From: Amanda Scholes on behalf of Planning.Responses
Sent: 30 May 2019 09:19
To: Planning Scanning
Subject: FW: LU/324/18/PL The Nelson Hotel, 61 Pier Road, Littlehampton
Attachments: SK.20190517.jpg; Nelson Hotel, Littlehampton_20190517.pdf

Site:	The Nelson Hotel, 61 Pier Road, Littlehampton
Status:	Full Planning Application
App. No:	LU/324/18/PL
Revision:	A (April/ May, 2019)
Date:	17 th May, 2019

SOUTH TERRACE / ALLEY ELEVATION (SOUTH EAST)

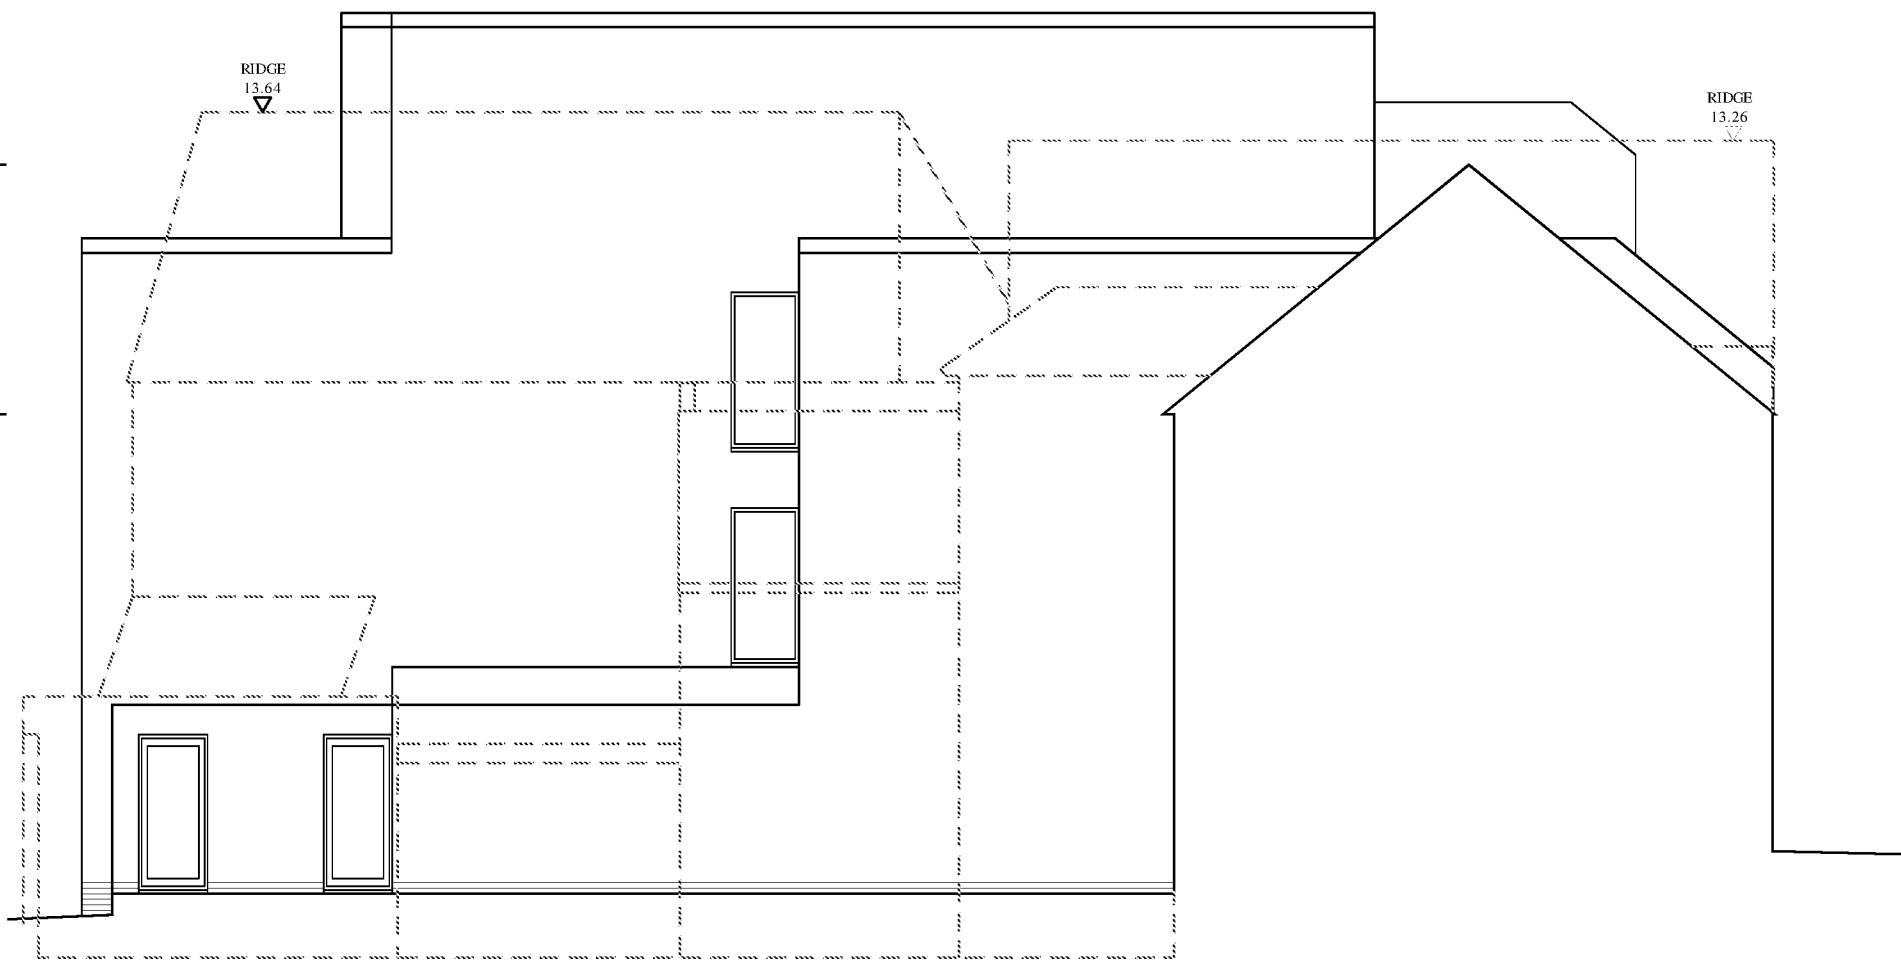
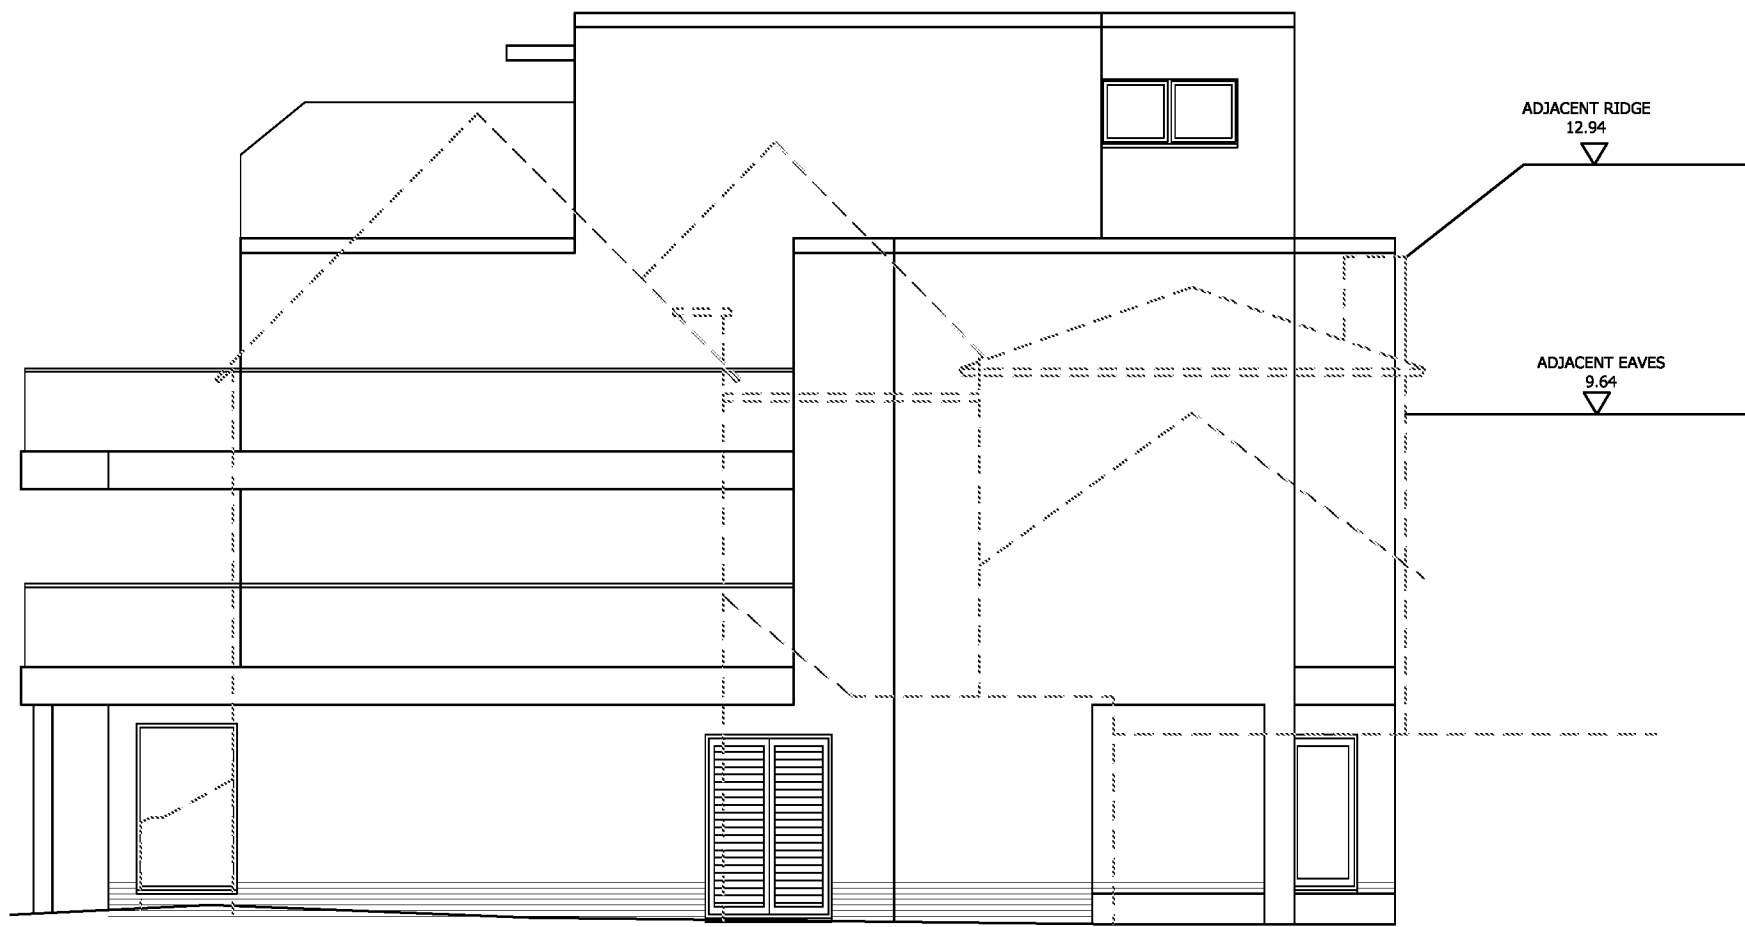
- While integration may be achieved through sensitive massing and materials, the impact of the proposed scheme is heightened through;
 - Exceeding the neighbouring building line and eaves heights.

- Re-orientating the ground floor entrance to the plot boundary (rather than maintaining the line of the existing building and the proposed upper level) with the impact of presenting the side of the building when approaching from South Parade.

- Adopting different materials to the red bricks of South Parade or the white render and timber weatherboarding of Pier Road.
- It is unclear why cladding panels and a Staffordshire Slate Blue brick have been adopted rather than seeking to marry with the materials of neighbouring properties.

- There remains a concern for the over development of the plot; it is noted that the revised scheme appears to project over the ground floor service area while deep front balconies extend to the curtilage of the plot rather than strengthening the building line and views along South Parade.

- Return the building line of the ground floor along South Terrace to match the upper levels; this re-focuses the frontage towards the approach from South Terrace and conceals the side of the building alongside the existing property.
- Potential Juliette balconies on this elevation; the deep cantilevers that are presently proposed seek to strengthen the alignment of the street rather than respond to the proposed building line and neighbouring building.
- Alternately, if the intent were to realign the building towards the street, it is recommended to maintain the existing building line along South Parade.
- Consider reducing the strong horizontal banding – this serves to emphasise different proportions to the existing buildings.
- Greater set back on the upper level to reduce visual impact and support views from South Parade.

- Consider lighter toned materials on the upper level – heavy tones/ materials emphasise the increase in height.
- Reduce heights and massing to the neighbouring property on Pier Road.
- Avoid cantilevering across the service area to maintain an invaluable external area for services, maintenance and storage and also, to avoid the over development of the plot.
